From: Euan Clark - Folkes Architects [REDACTED]
Sent: 26 May 2020 10:46
To: Andrew Wood <Andrew.Wood@arun.gov.uk>
Subject: RE: Roseland, The Causeway, Arundel - LY/5/20/PL

Re: Roseland, The Causeway, Arundel – LY/5/20/PL

Proposed Block Plan - 1:500 @ A1

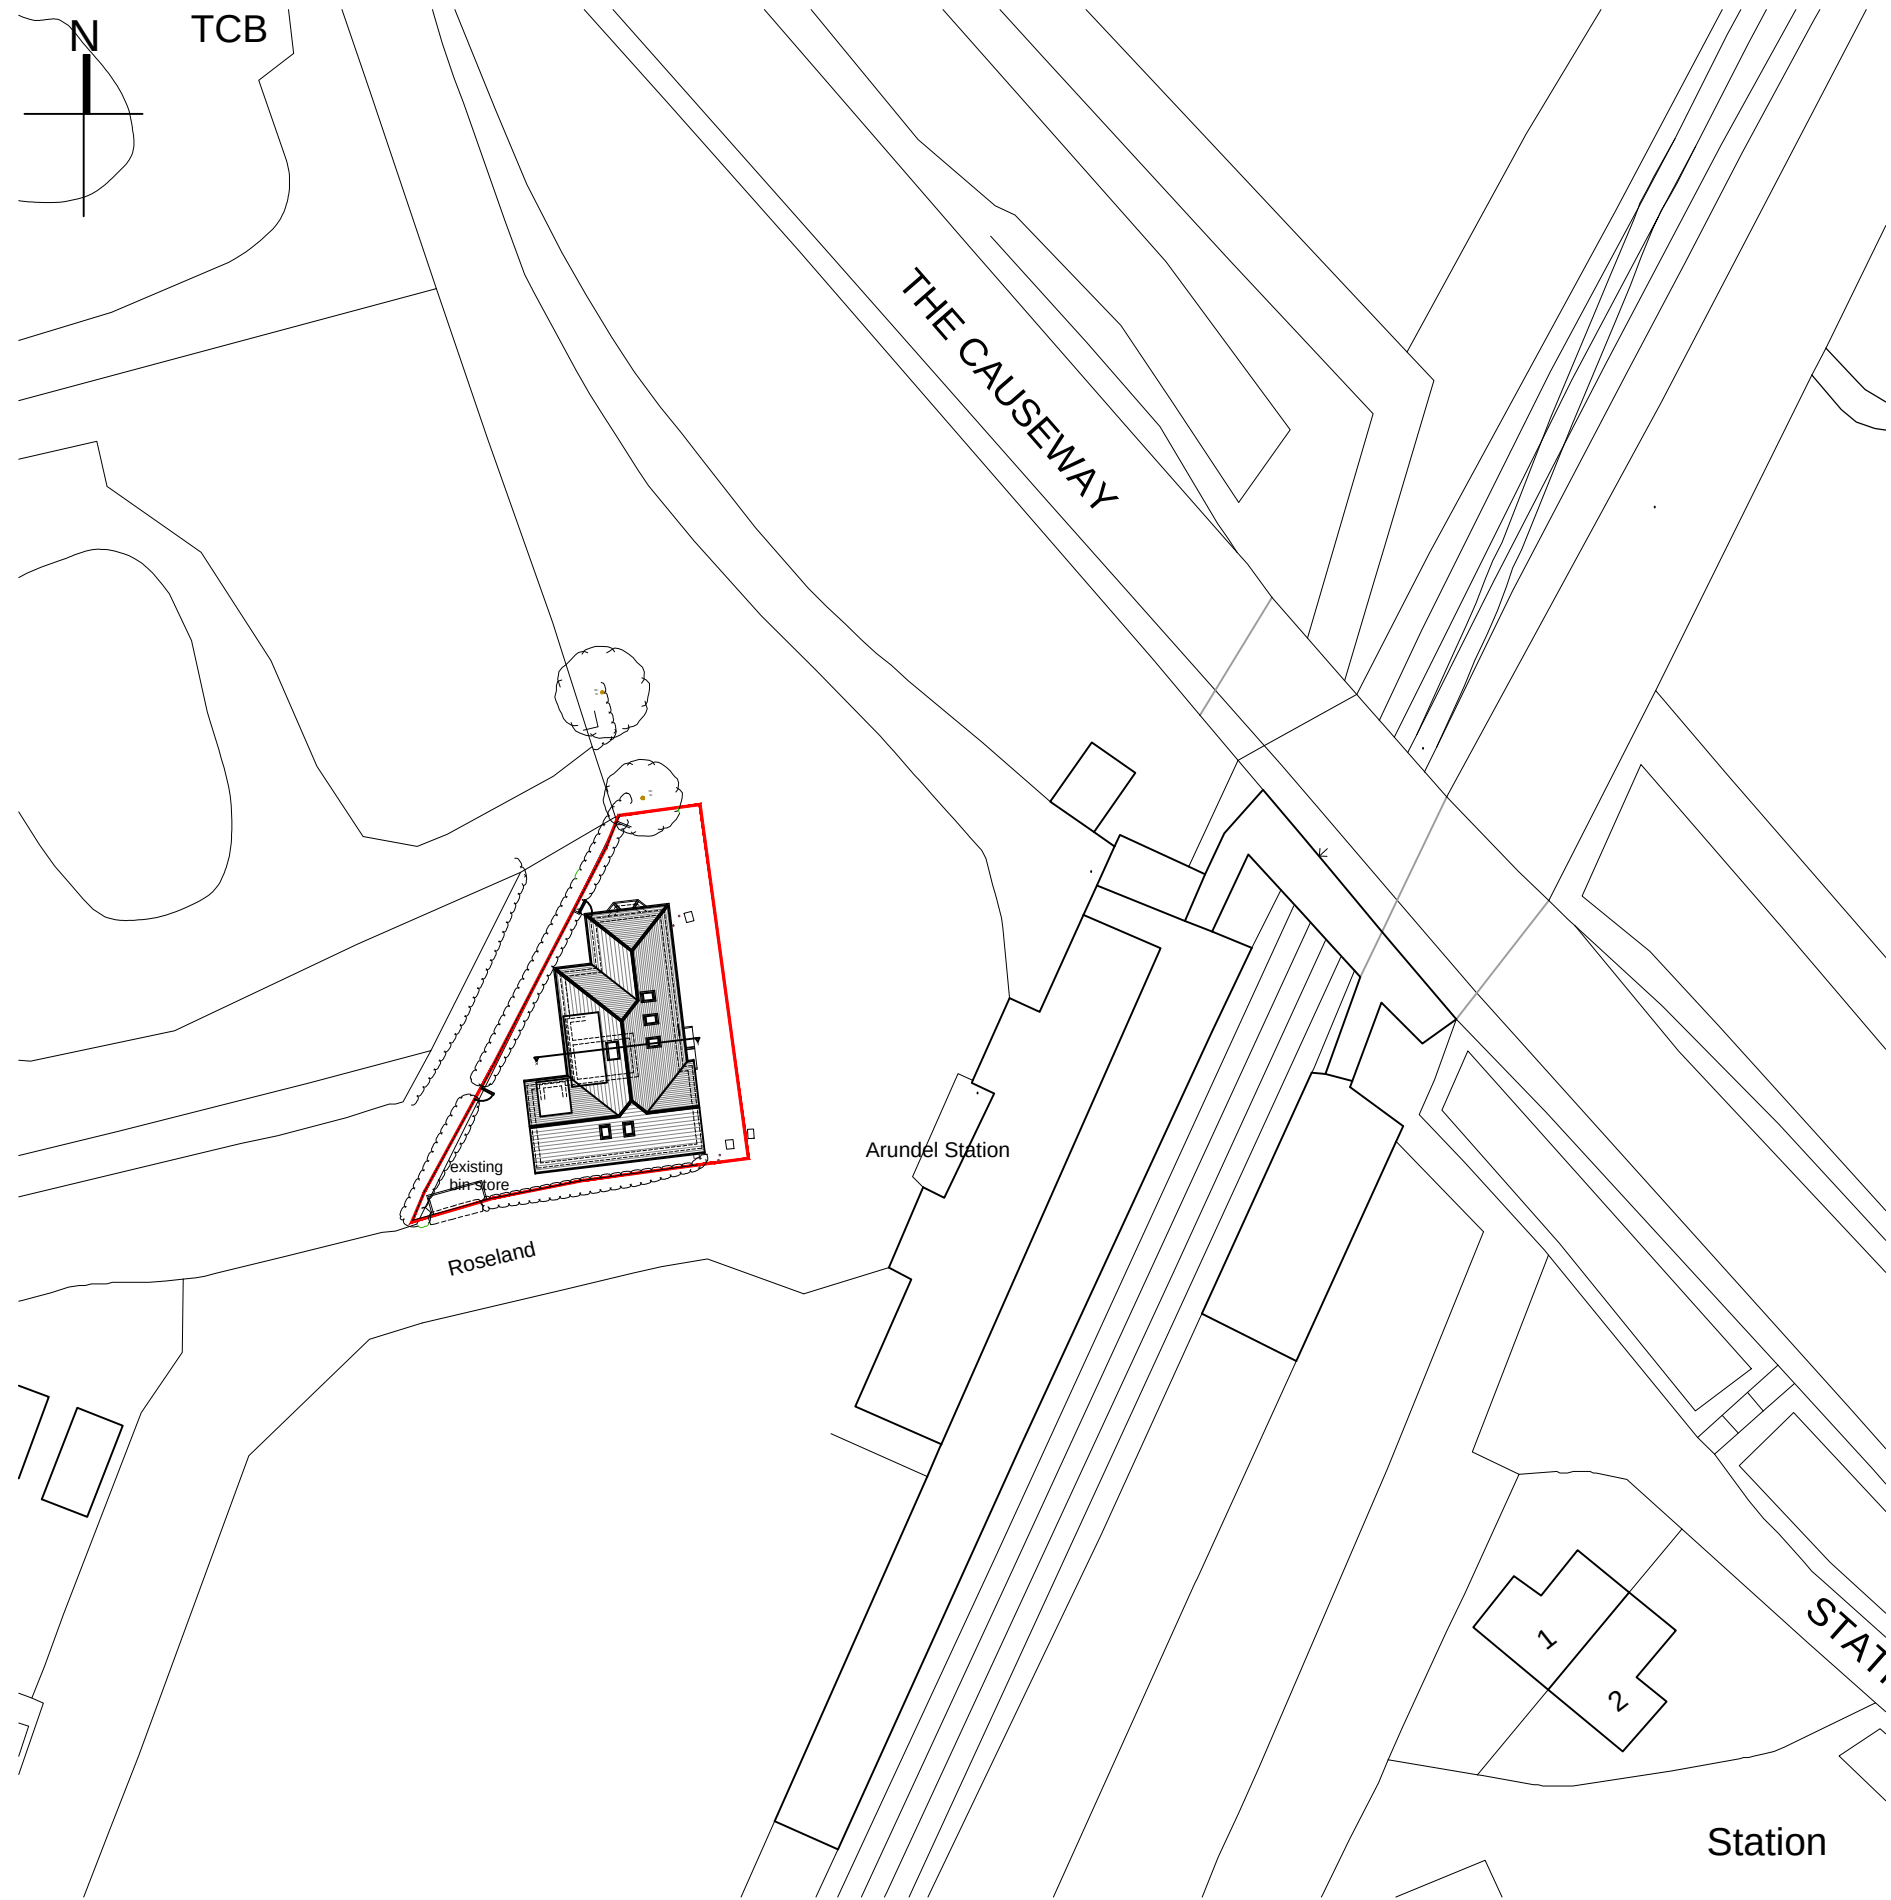
The addition of two flats to the development will generate the need for four additional car paring spaces. Can you demonstrate on a plan how these additional parking spaces will be provided on site ?

Thank you for your time earlier today, we have discussed the parking with our client and they confirmed that the bin store is actually located to the north of the site so we have utilised an underused triangle of the site to the south west to provide 02no. additional parking spaces within the site as we were unable to provide the additional spaces to the east (front) of the site.
